**SSD-10399 - ENVIRONMENTAL IMPACT STATEMENT
PROSPECT LOGISTIC ESTATE - SEVEN INDUSTRIAL WAREHOUSING BUILDINGS,
ASSOCIATED OFFICES AND HARDSTAND/CAR PARKING AREAS
44 CLUNIES ROSS STREET, PEMULWUY**

Thank you for your referral via the Major Projects Portal requesting Transport for NSW (TfNSW) comment on the Environmental Impact Statement (EIS) for the Prospect Logistics Estate (SSD-10399).

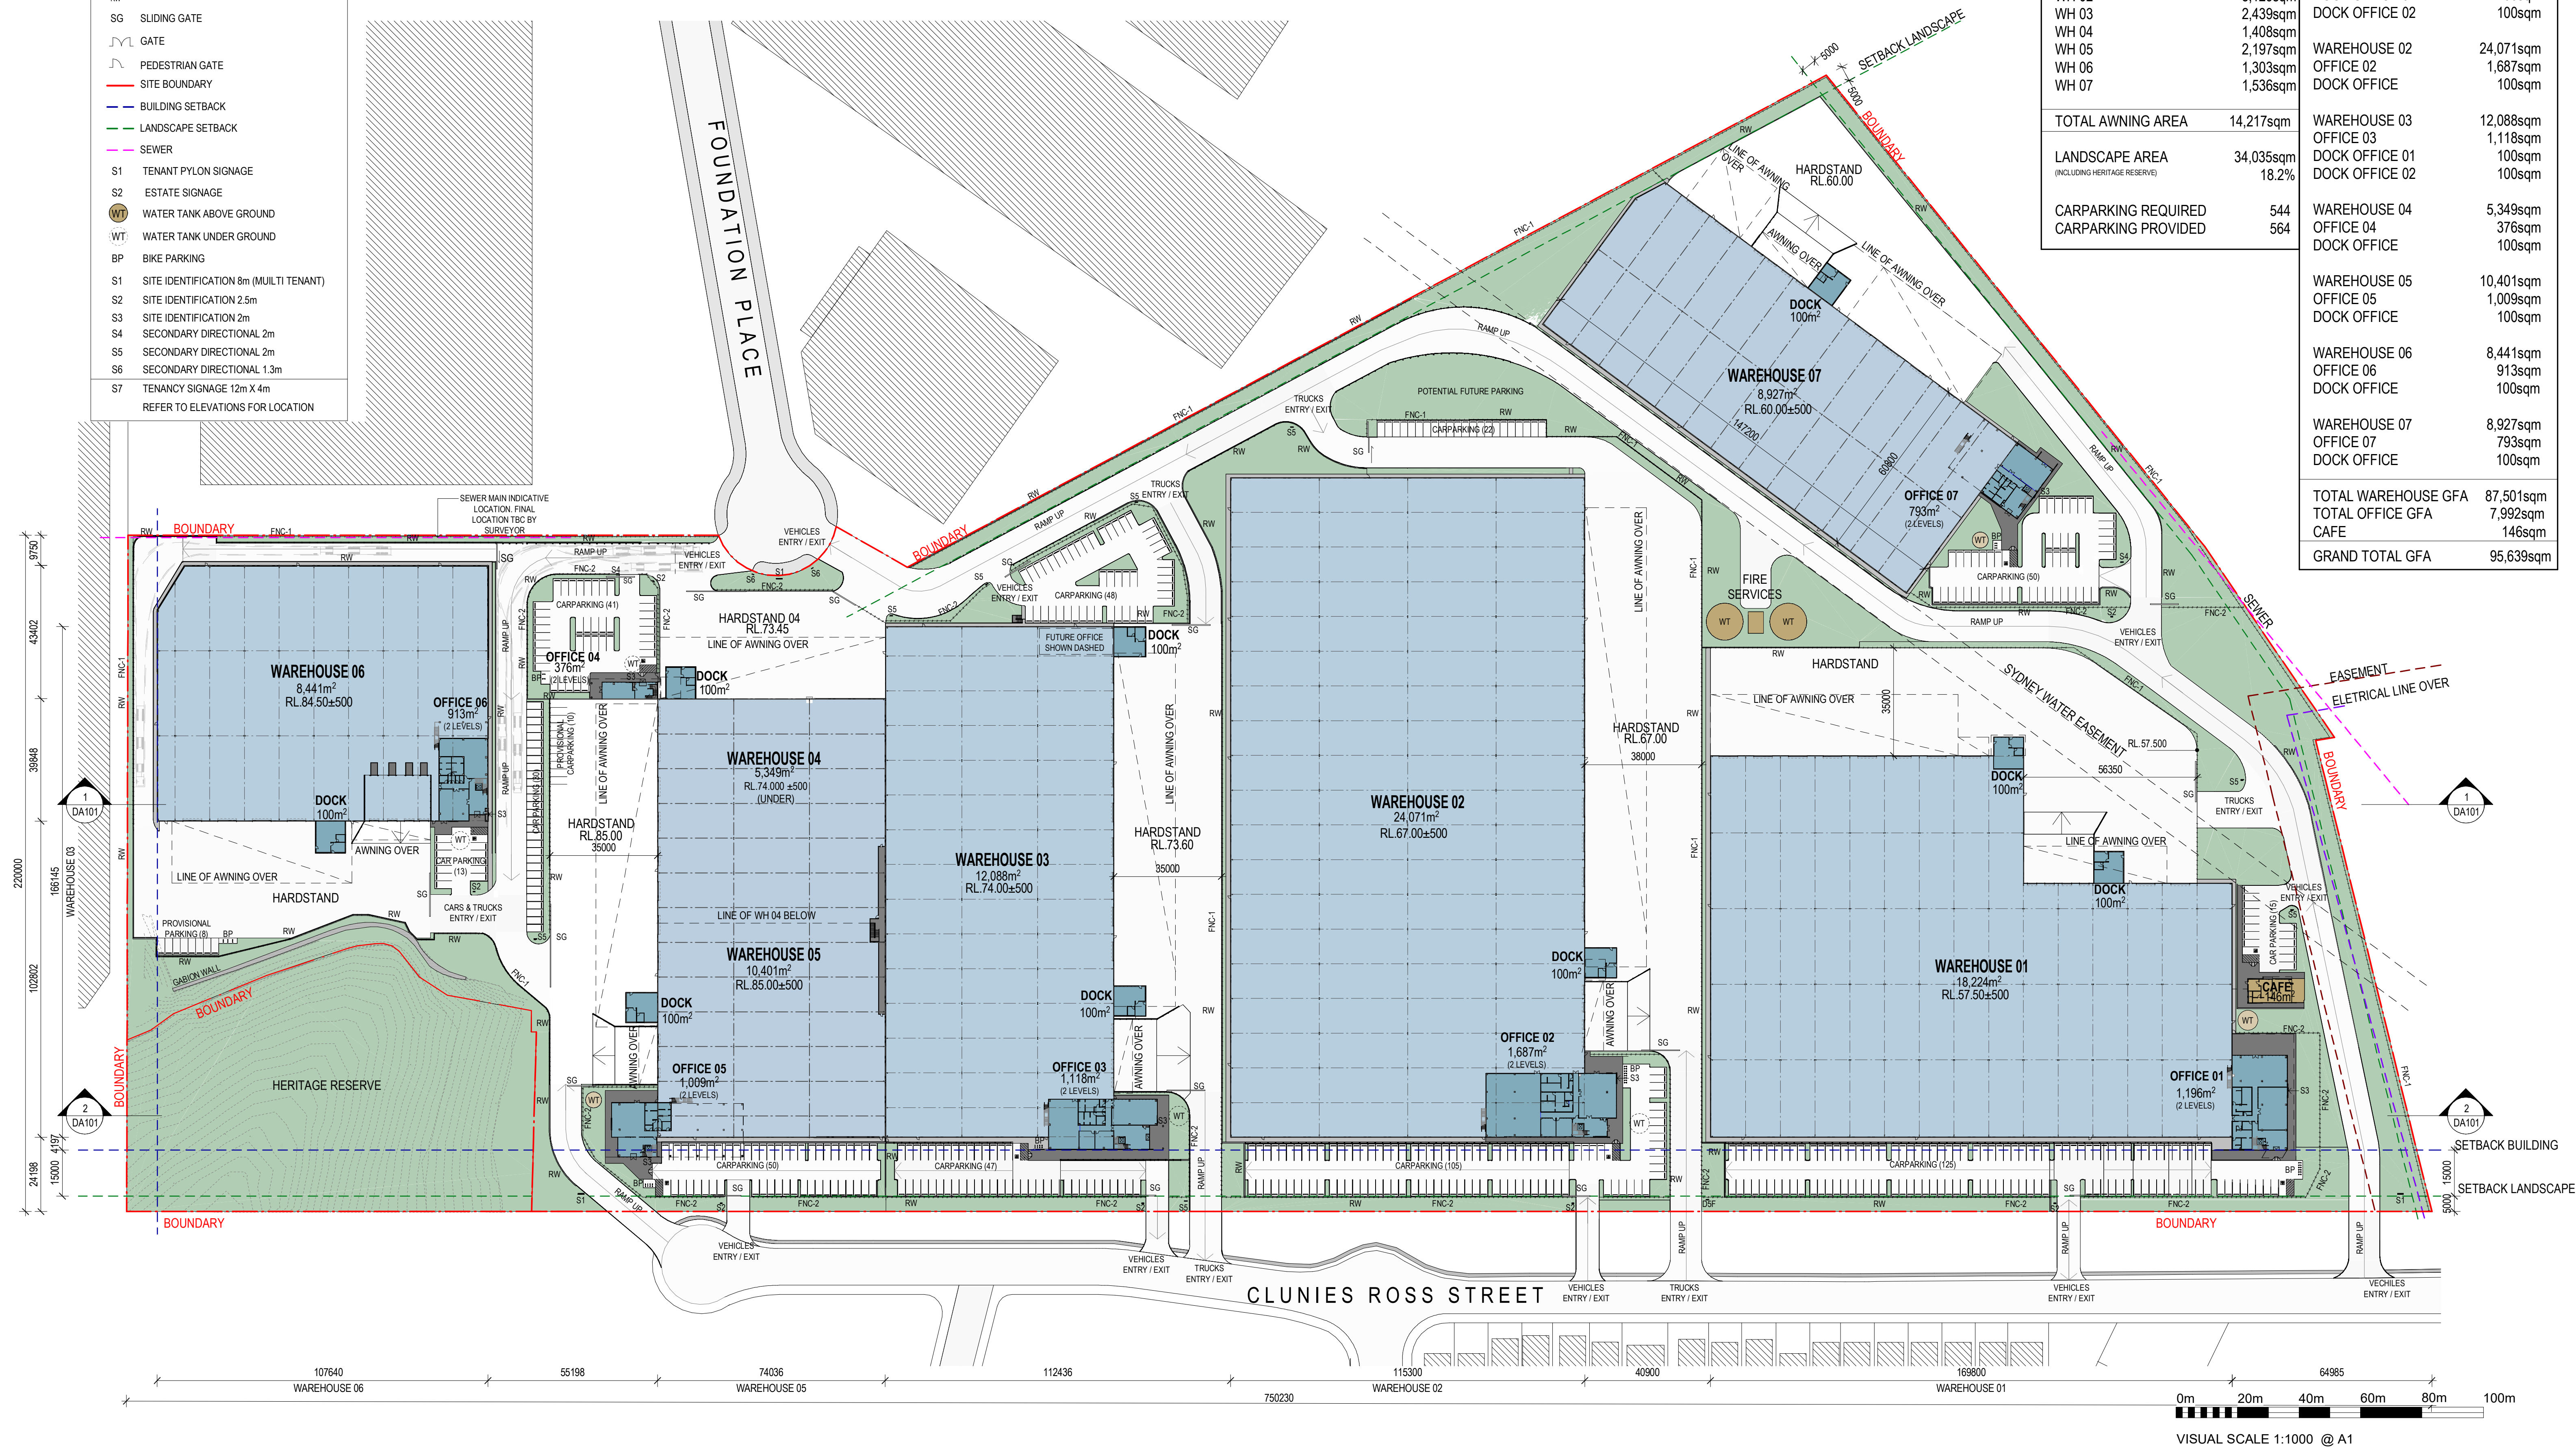
1. The layout of the proposed car parking areas associated with the subject development (including, driveways, grades, turn paths, sight distance requirements in relation to landscaping and/or fencing, aisle widths, aisle lengths, and parking bay dimensions) should be in accordance with AS 2890.1-2004 and AS2890.6-2009.

2. All vehicles are to enter and exit the site in a forward direction.
3. All vehicles are to be wholly contained on site before being required to stop.
